Markup Summary

[5] 204 GRADING AND EROSION CONTROL PLAN (2)

DESIGNED EJG	DRAWN KRK	CHECKED EJG
SCALE (H): 1" = 80'		
SCALE (V):		
DATE: DECEMBER 20, 2018		
PROJECT NO. 096495003		
DWG. NAME 096495003_EC		
SHEET NO.		206

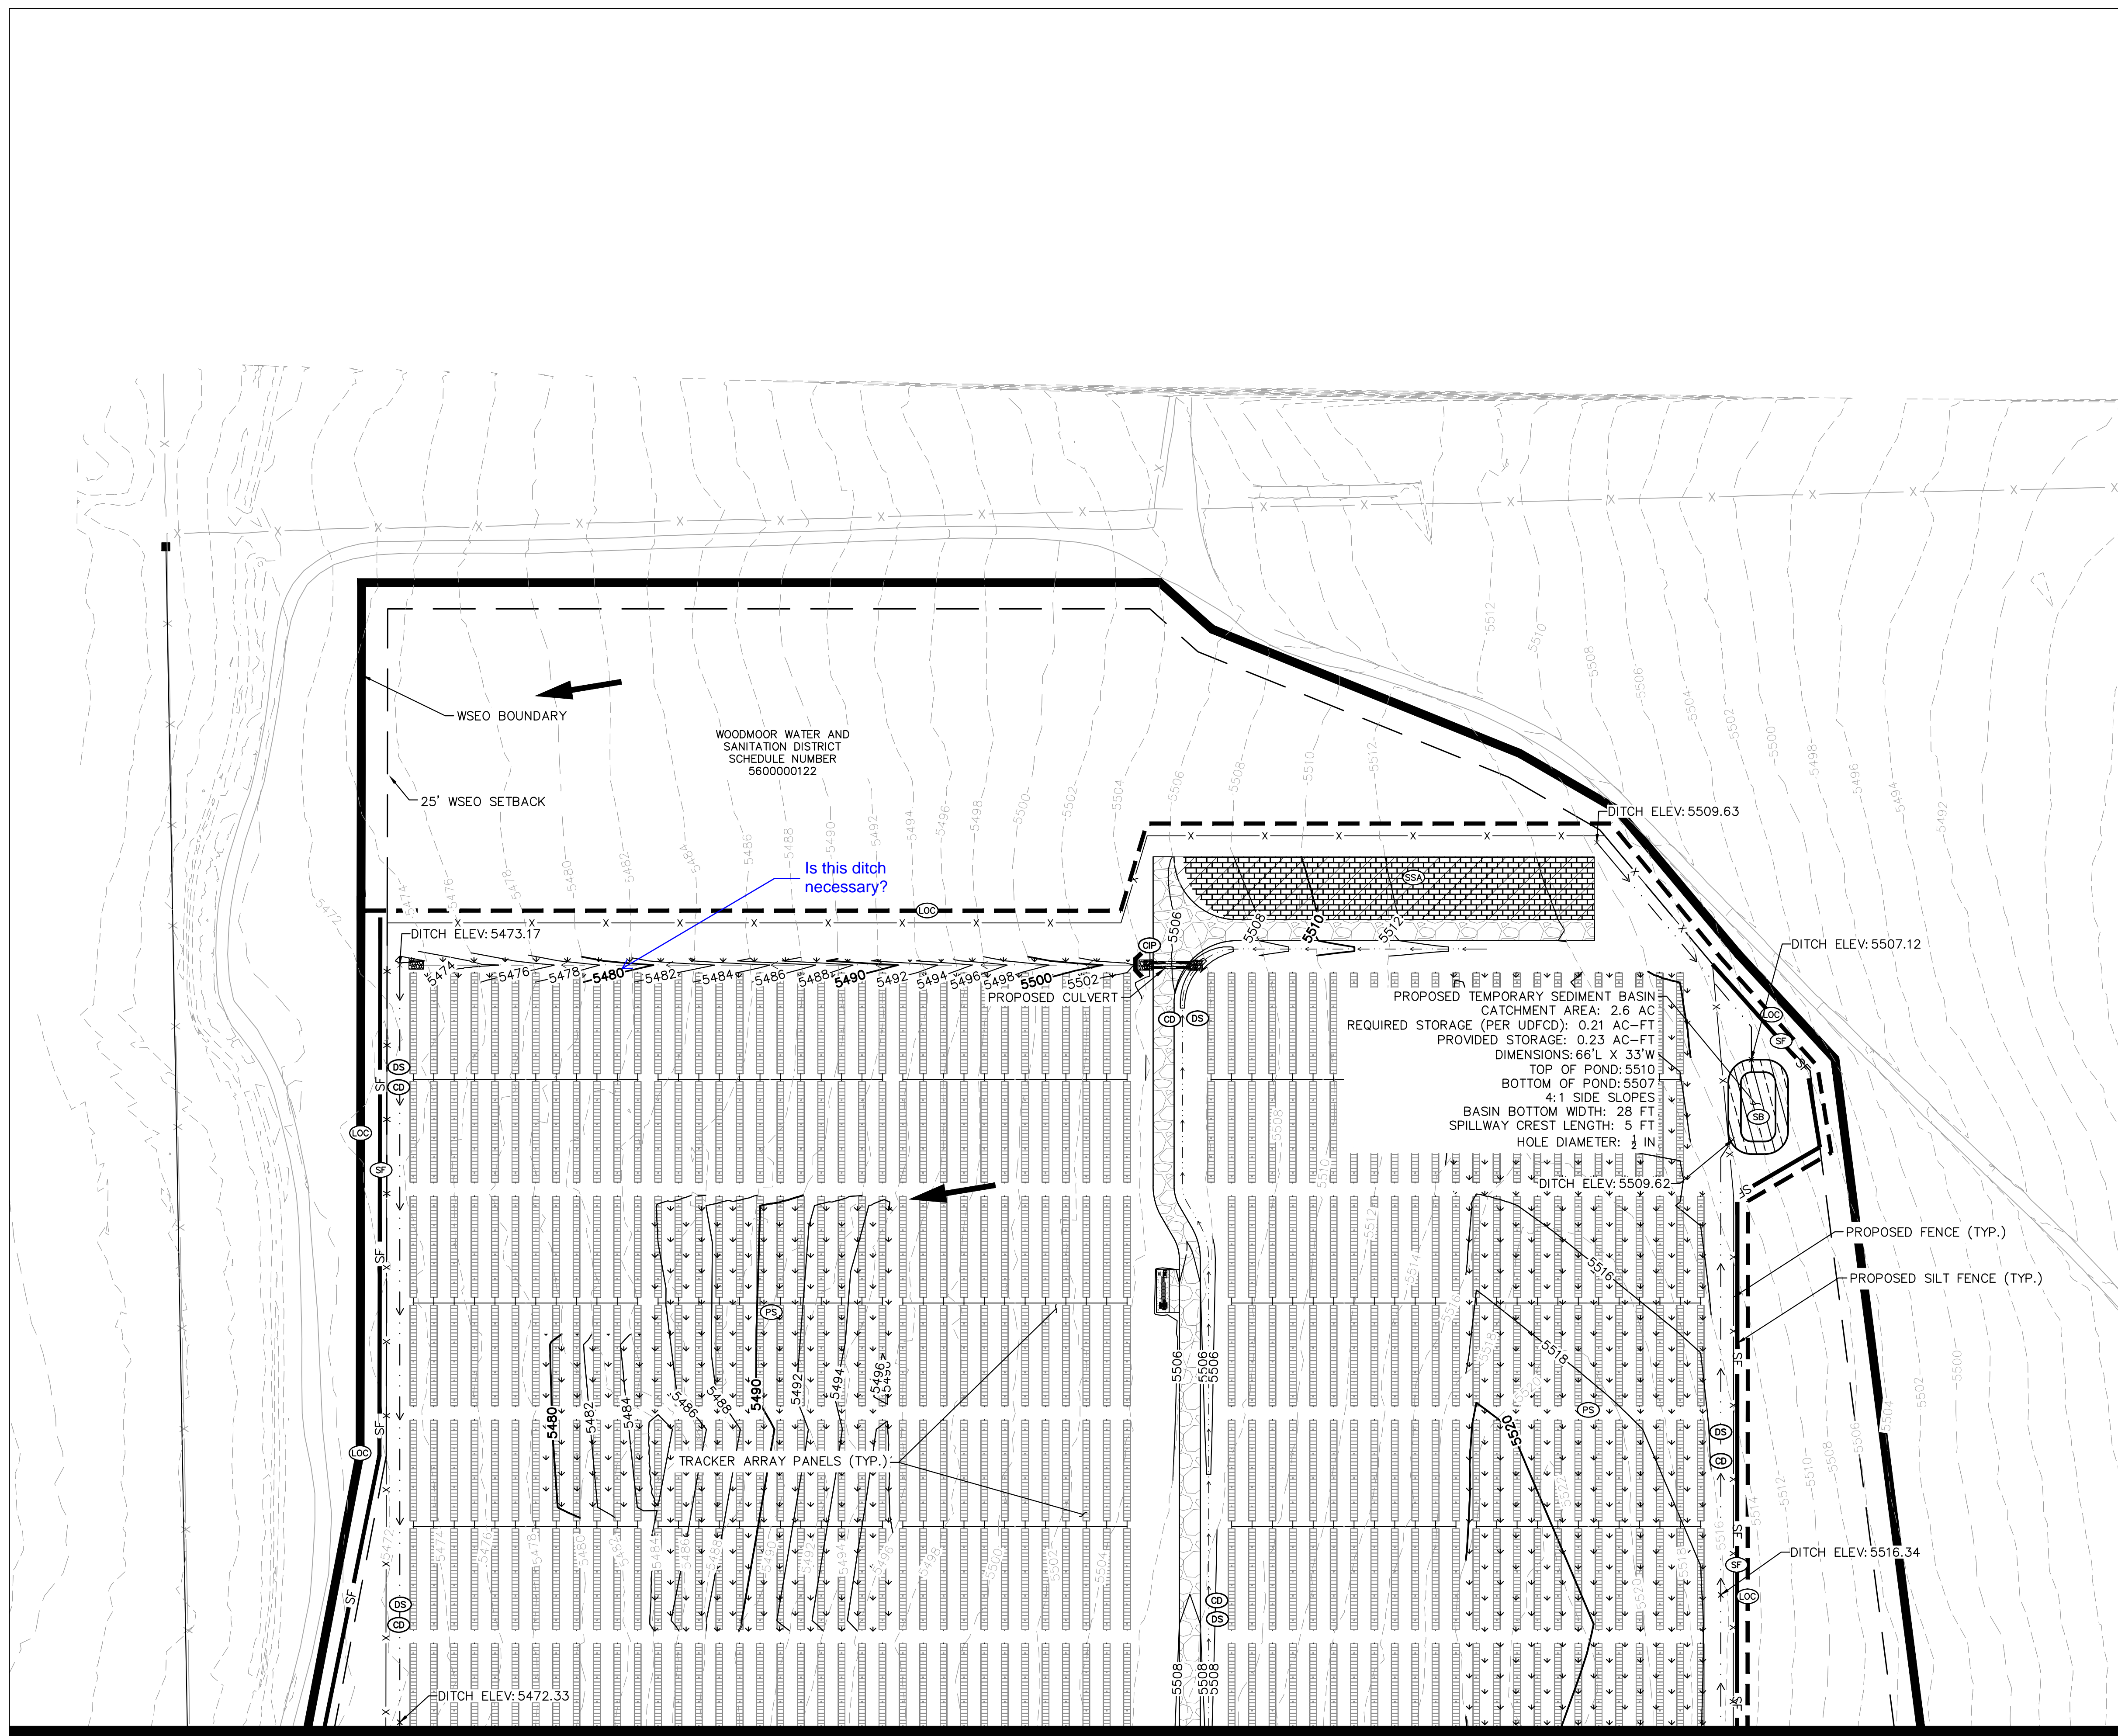
Is the overlap intentional (clarification needed) or revisions not complete?

Verify check dam leader locations.

Verify check dam leader locations.

DESIGNED EJG	DRAWN KRK	CHECKED EJG
SCALE (H): 1" = 80' SCALE (V):		SHEET NO. 207
DATE: DECEMBER 20, 2018		
PROJECT NO. 096495003		
DWG. NAME 096495003_EC

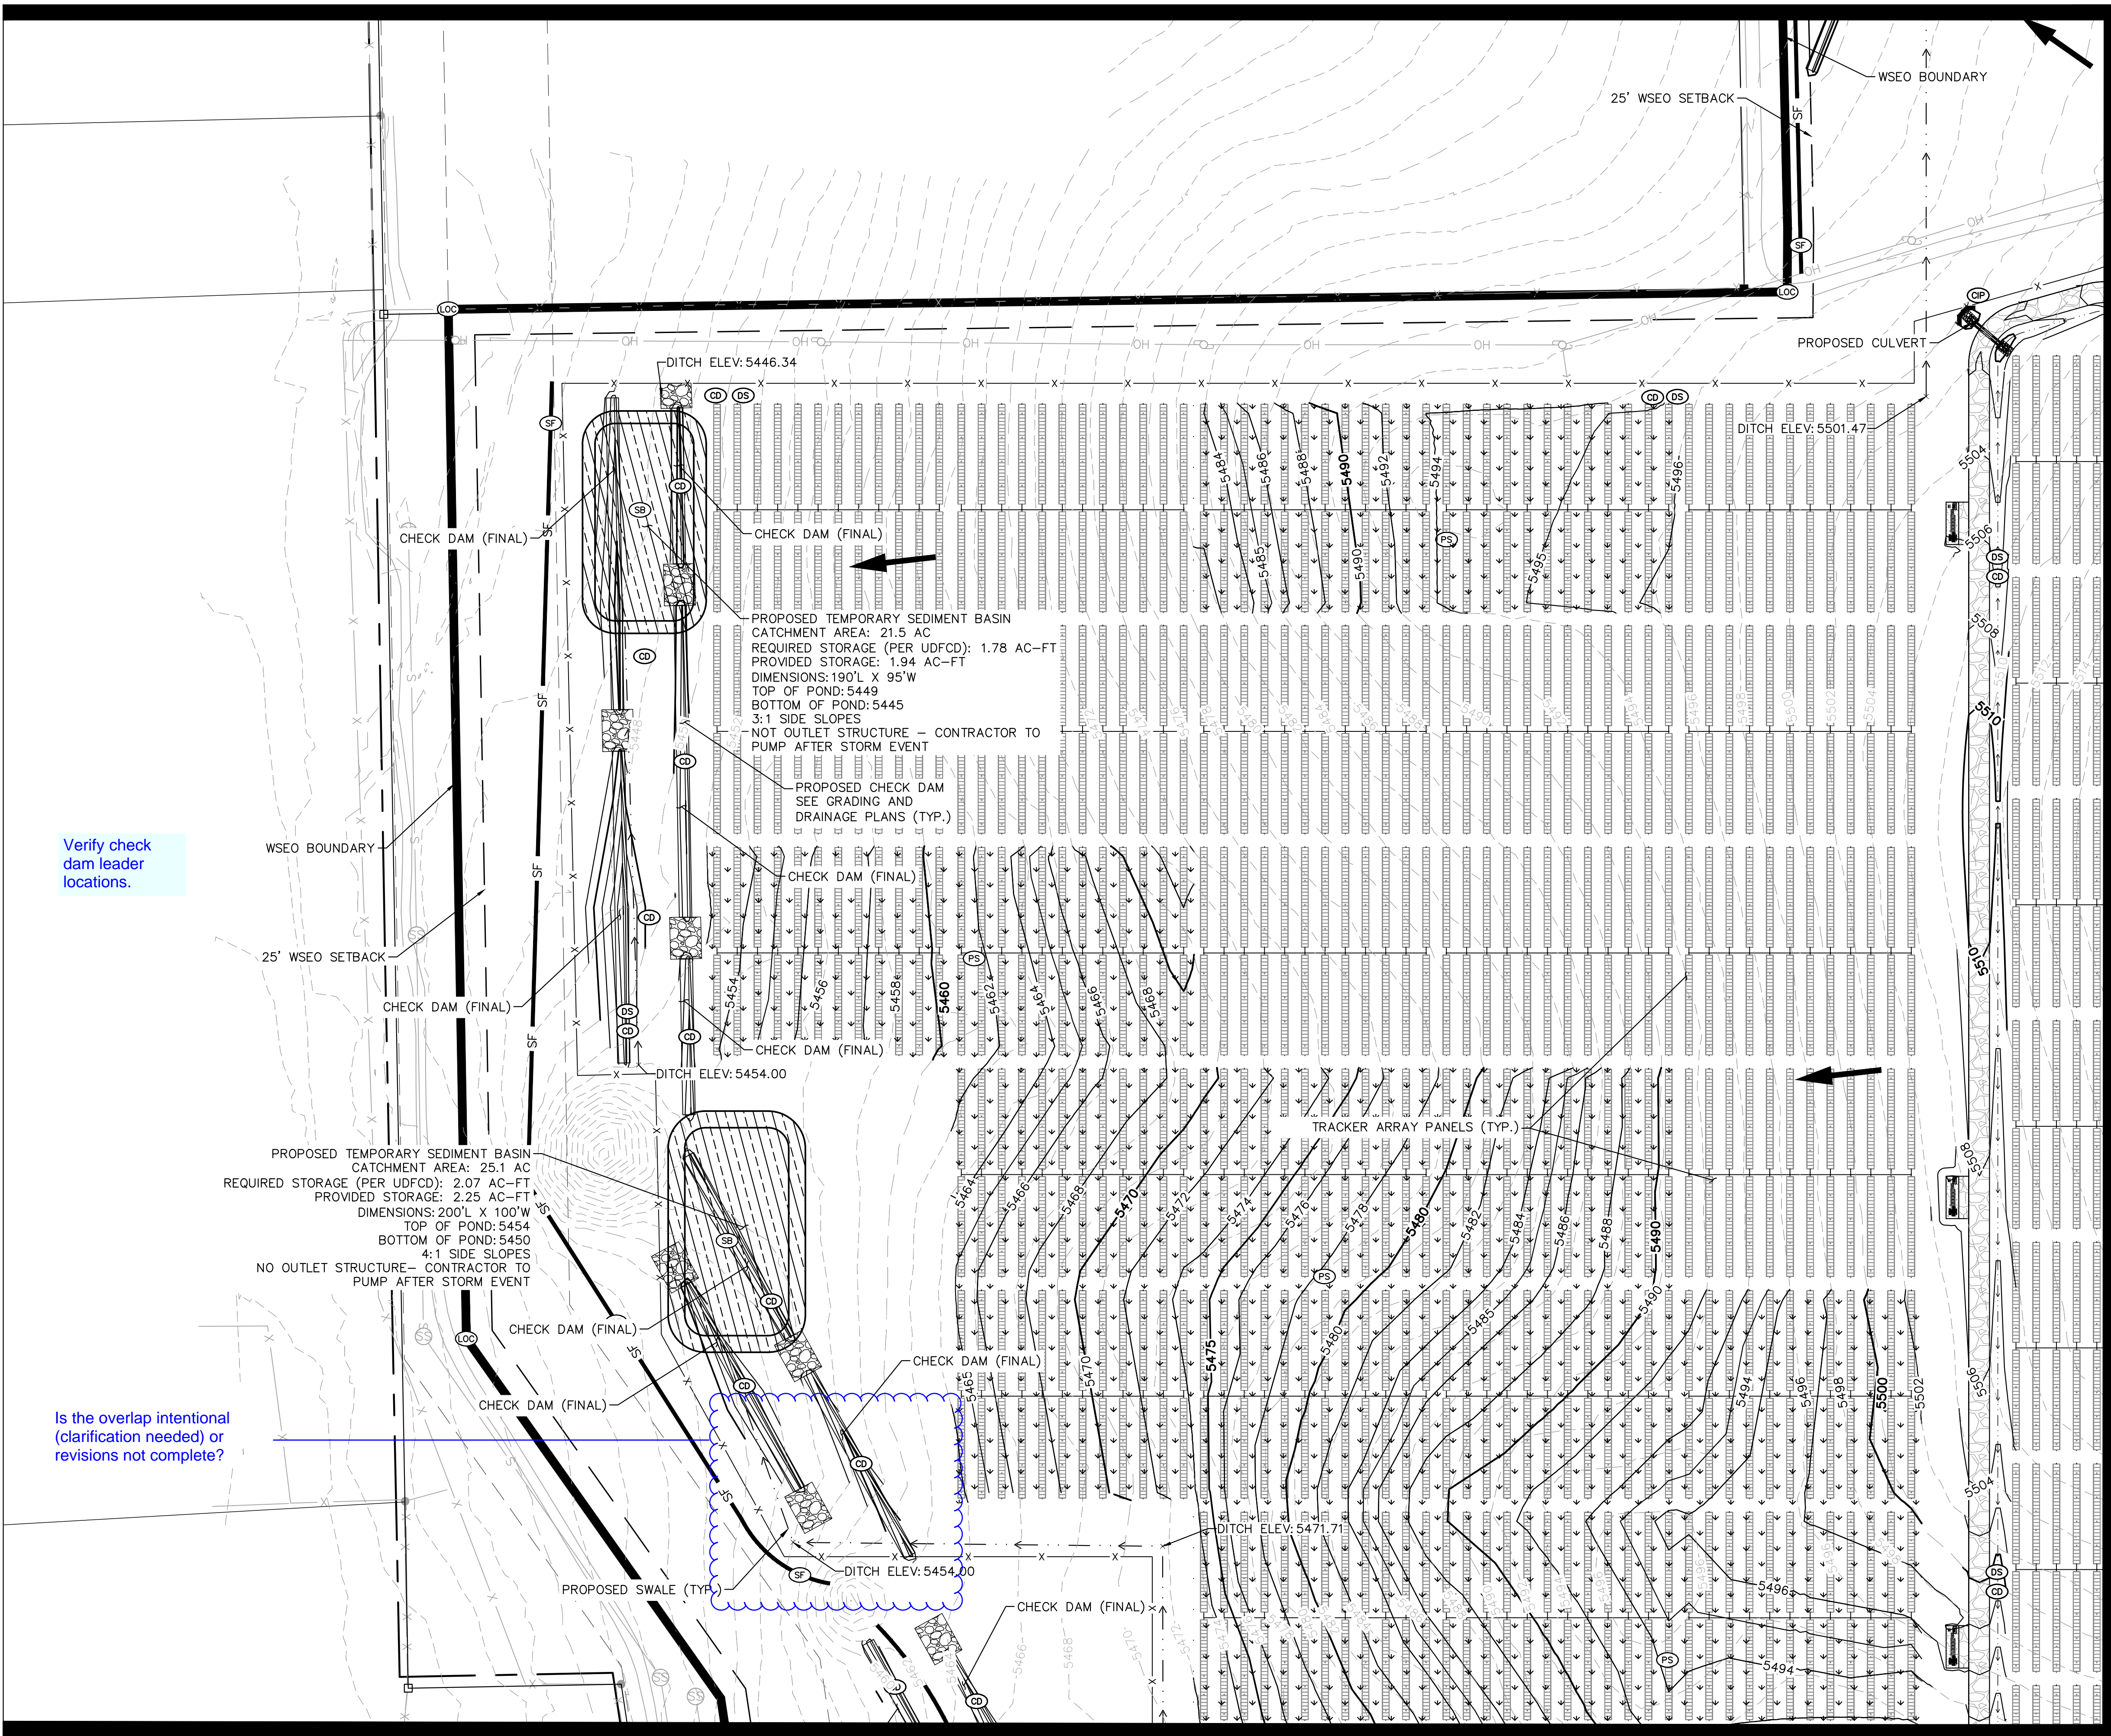
provide flow arrow

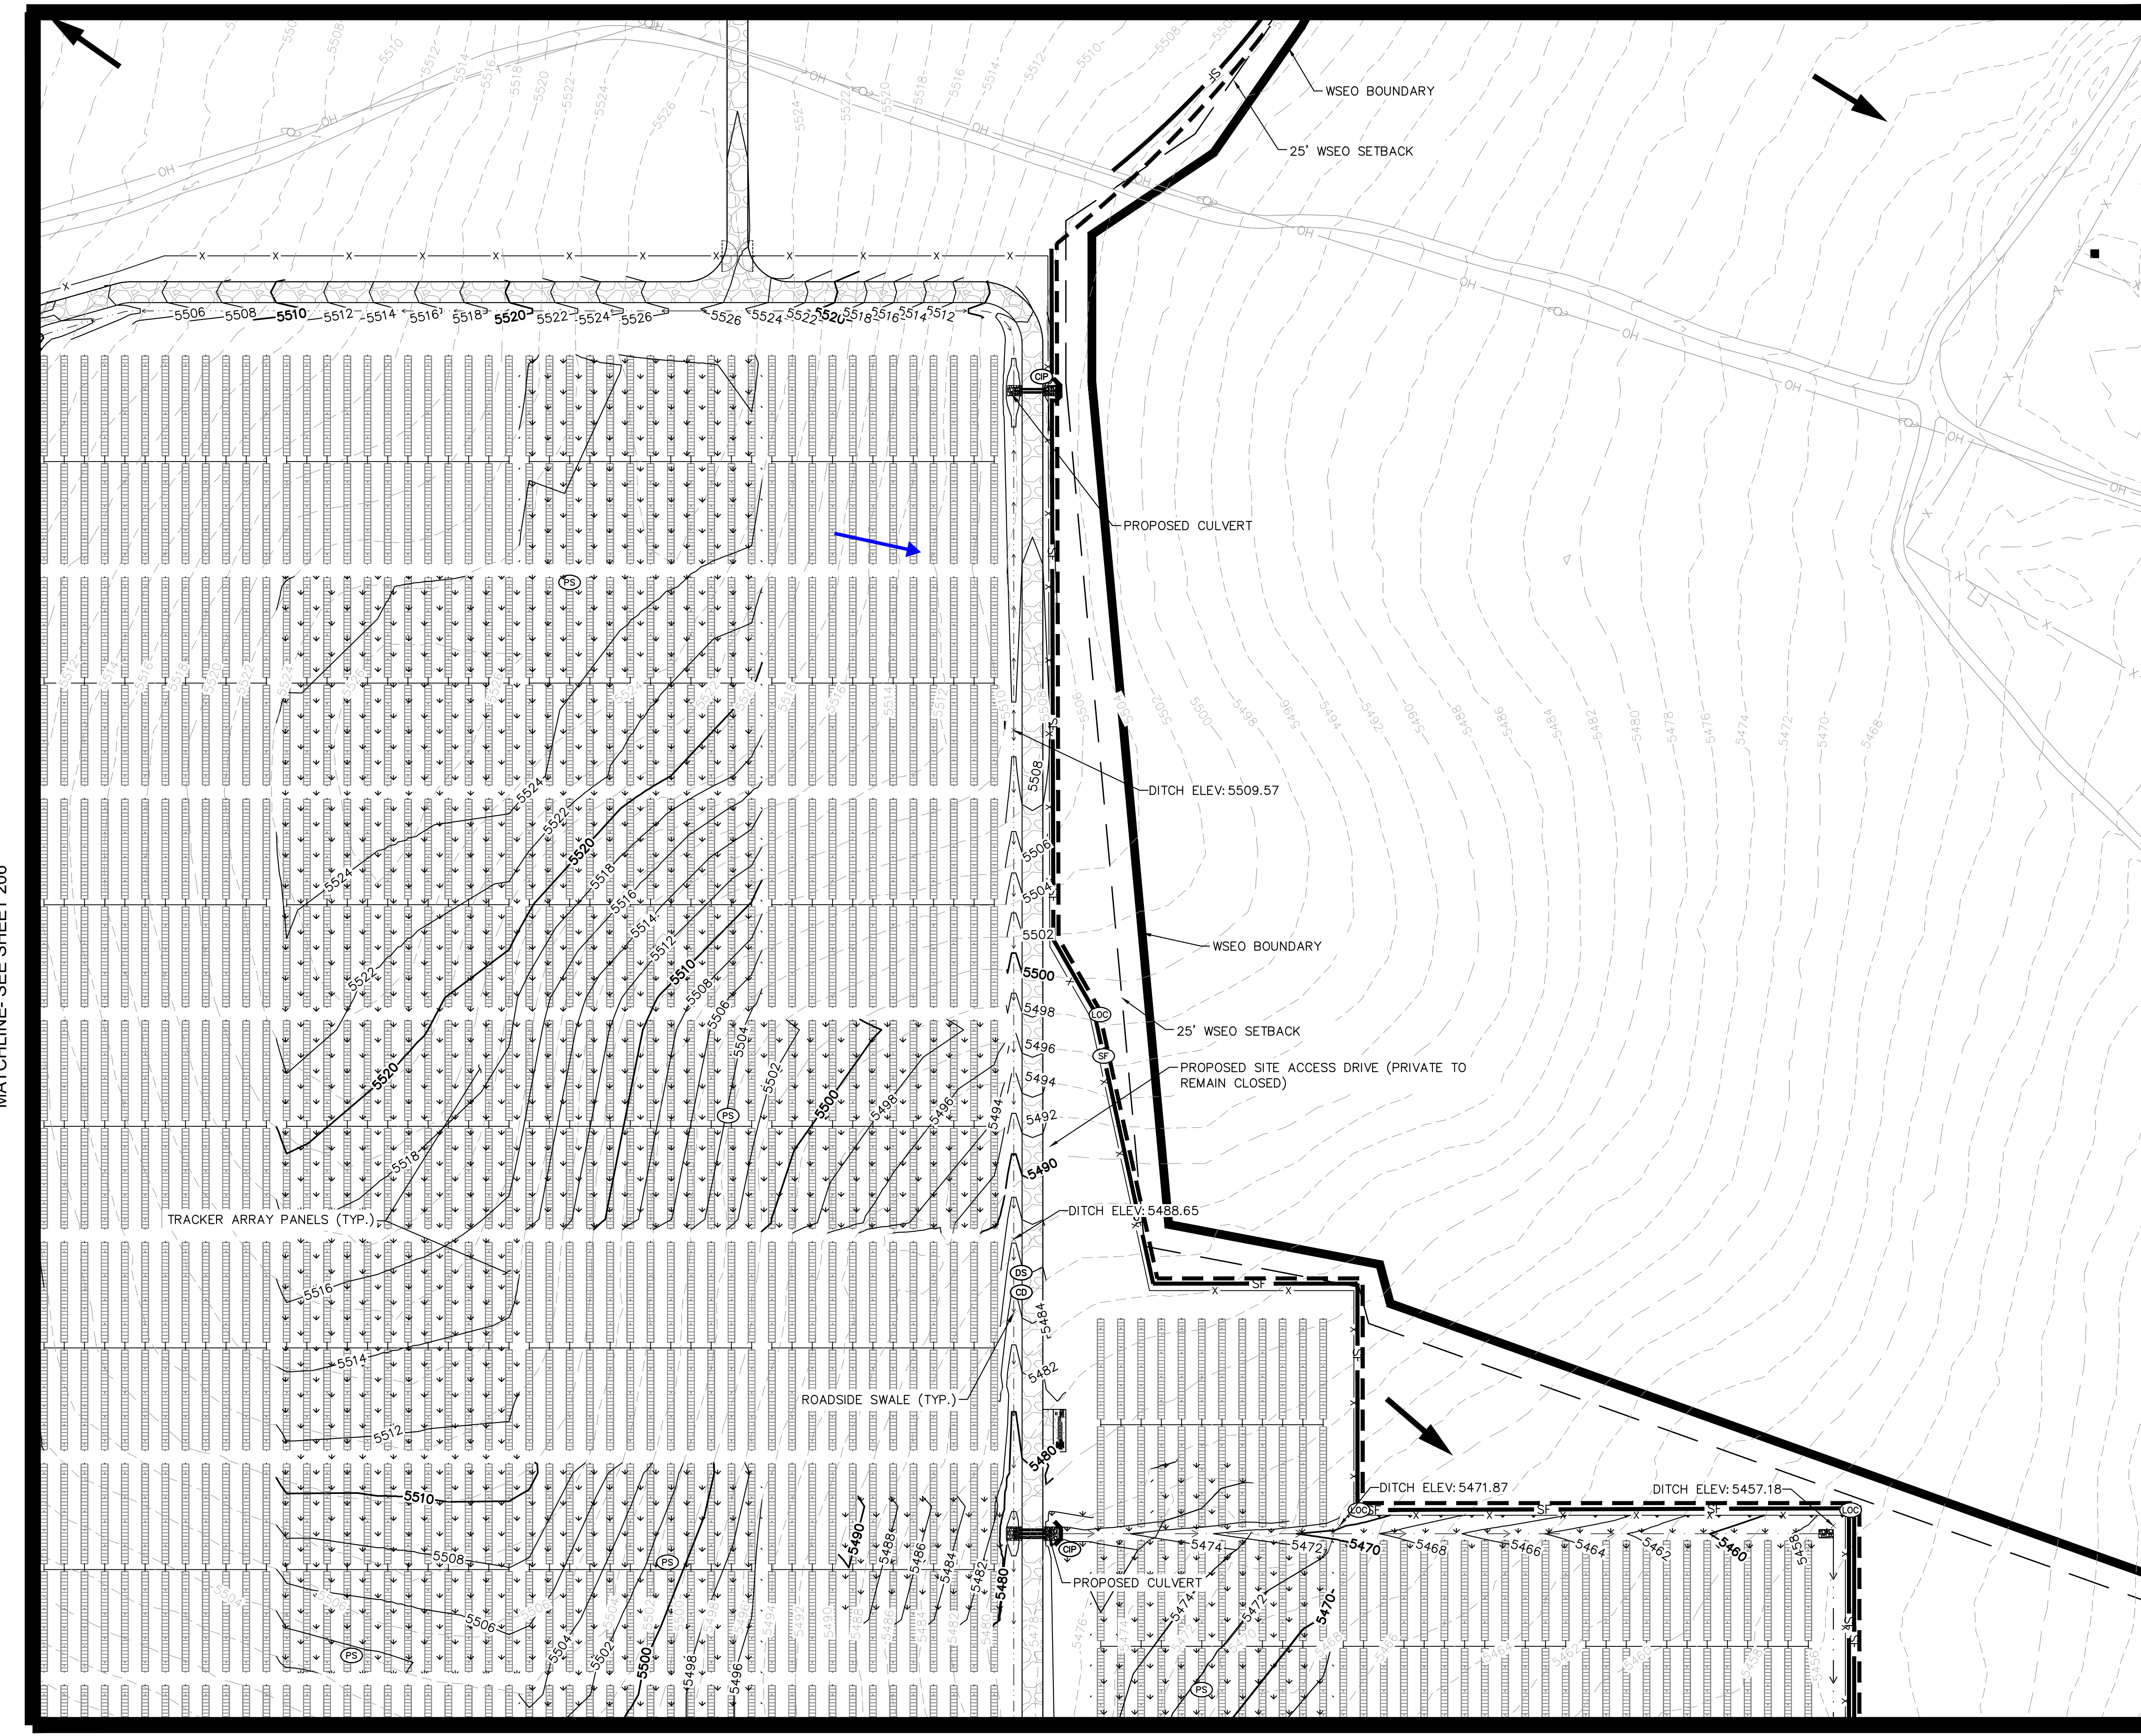
provide flow arrow

Is the swale supposed to flow this way? Is it necessary?

Verify silt fence location/alignment (should follow contours)
